Memorandum

TTPP REF: 19237

**RE: 23-43 & 45 TATTERSALL ROAD, KINGS PARK
RESPONSE TO SUBMISSIONS**

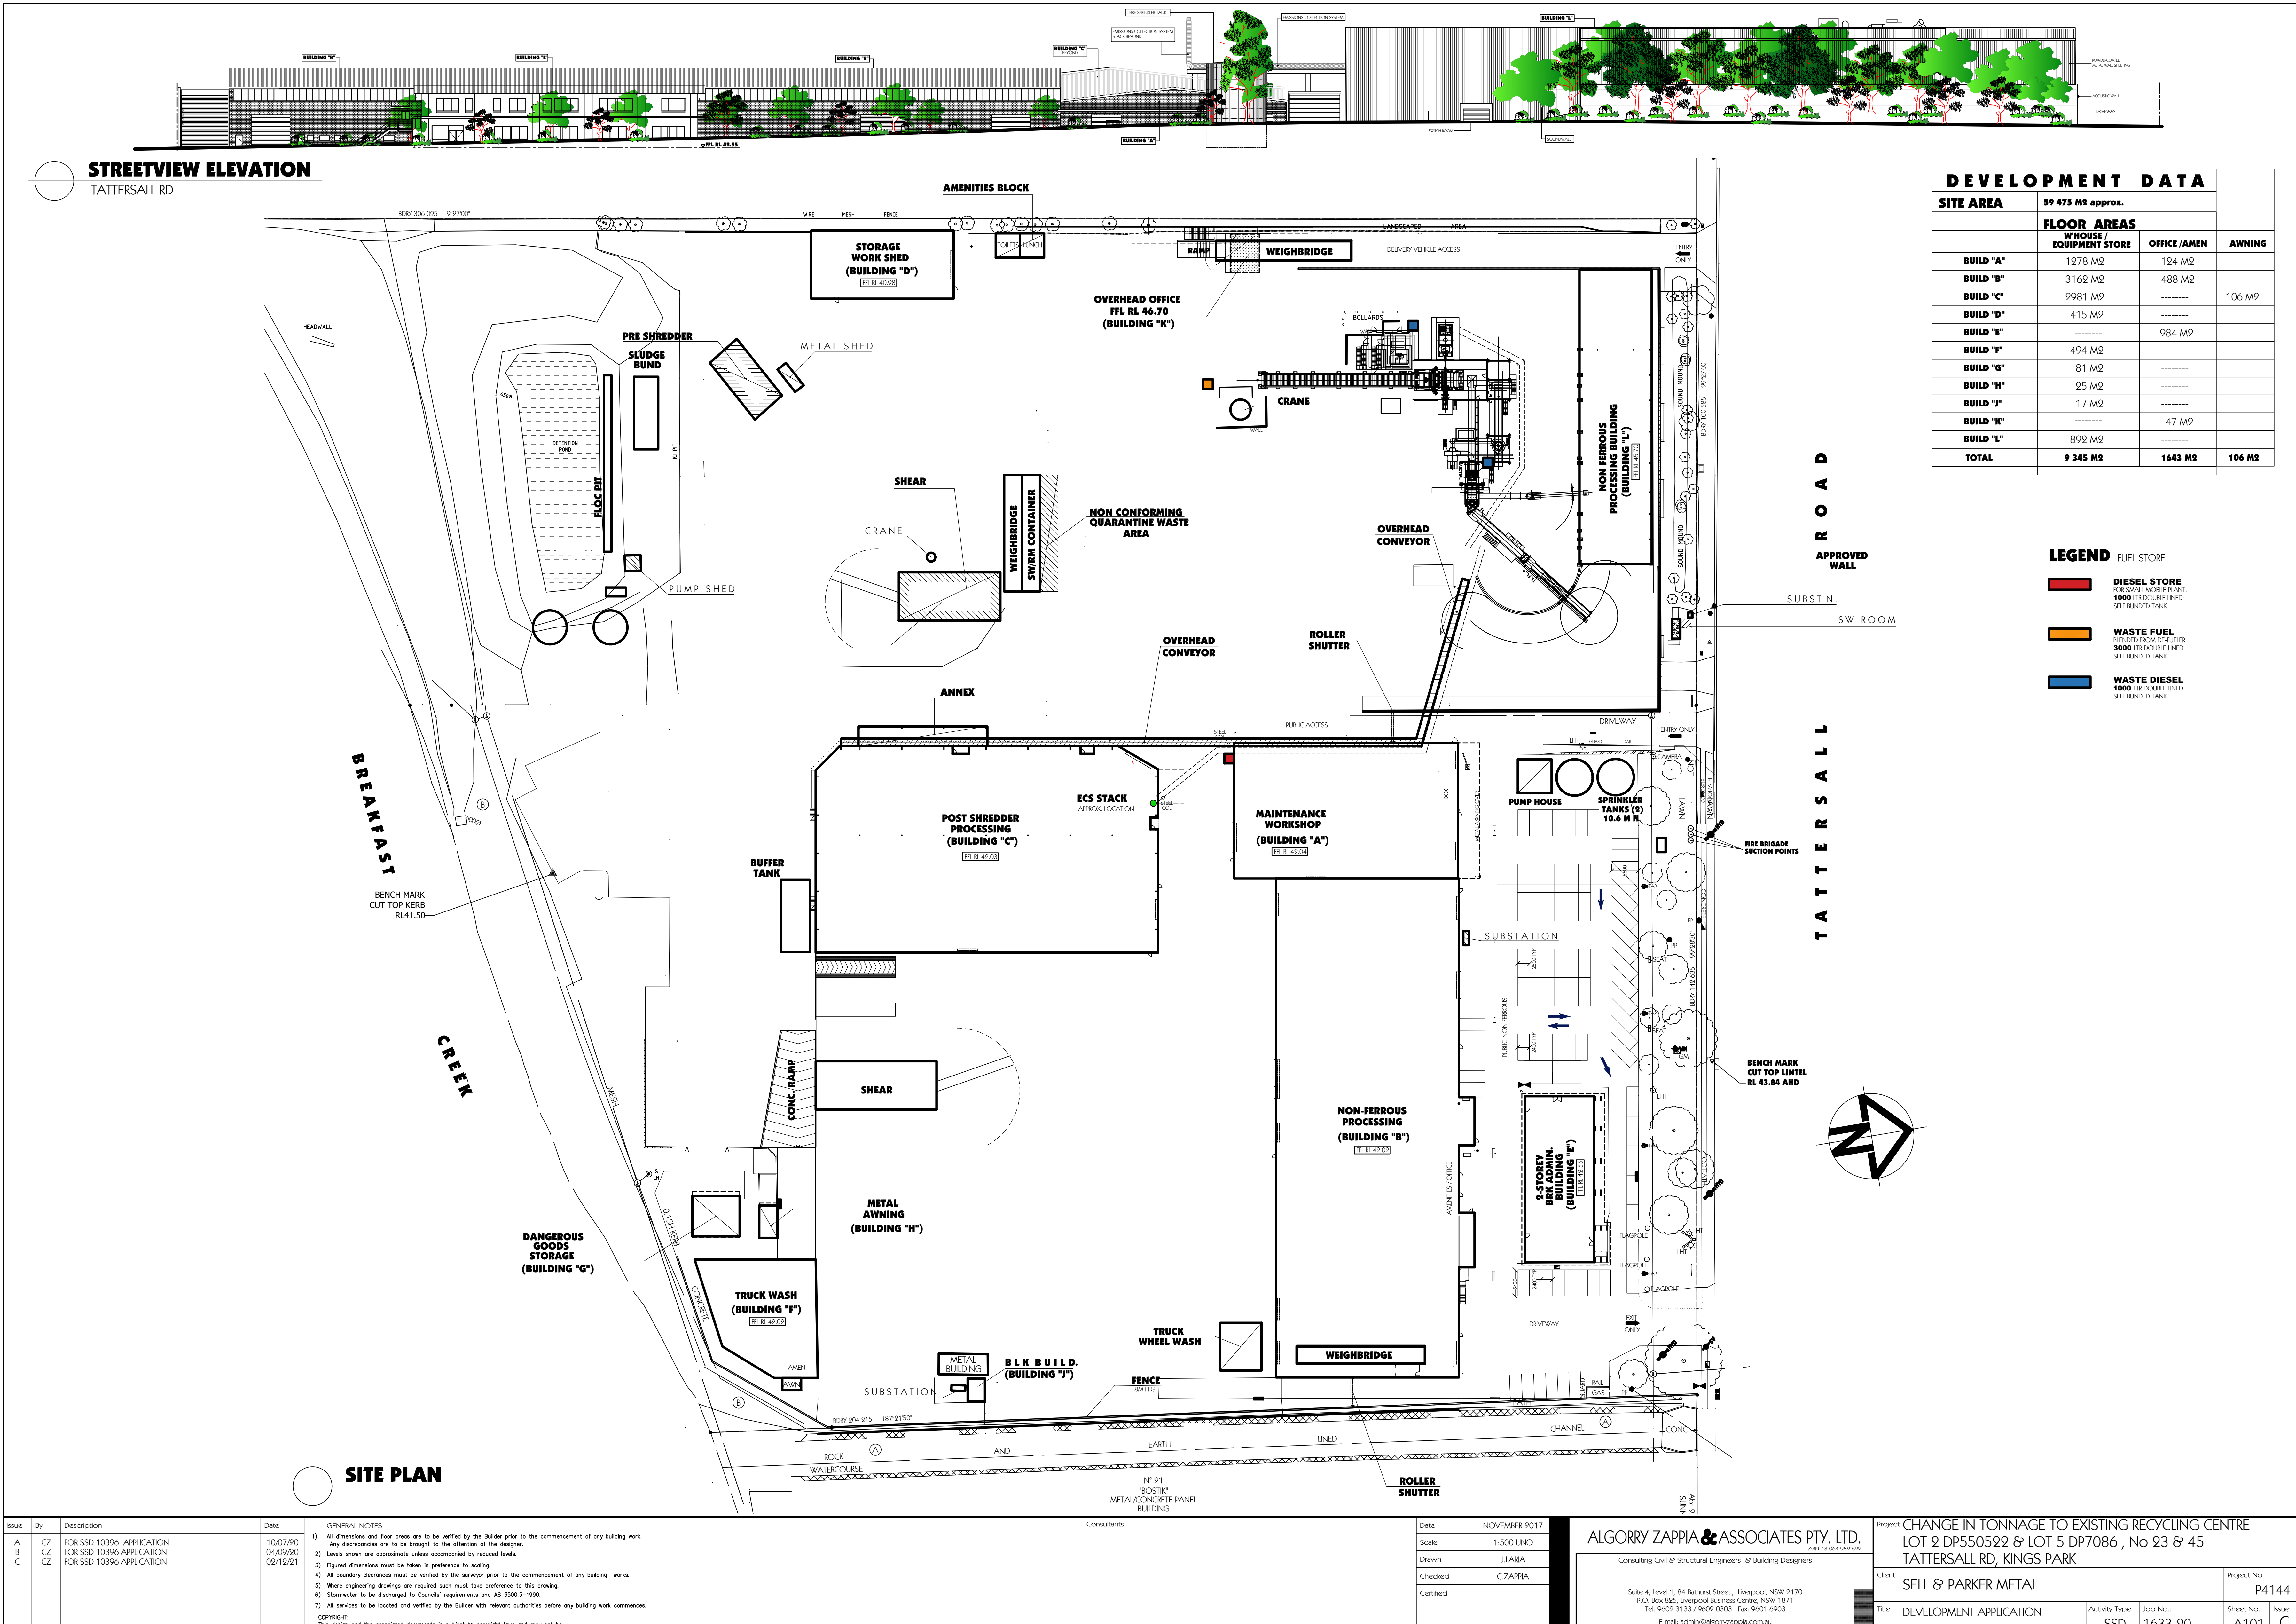
6. It would appear that Figure 6-1 in the Traffic Assessment (Appendix E of the EIS) shows heavy vehicles queuing/stacking in areas shown as stockpiles in the SP (Appendix G of the RTS). Please provide an amended Figure 6-1 that includes the proposed stockpile layouts and demonstrates there is sufficient room onsite for vehicle queueing.

The stockpile plan and vehicle stacking plan have been updated, ensuring that vehicles can manoeuvre through the site or be waiting in a stacking area without impeding stockpile access and site operations. The revised onsite staking plan has been provided in Attachment One.
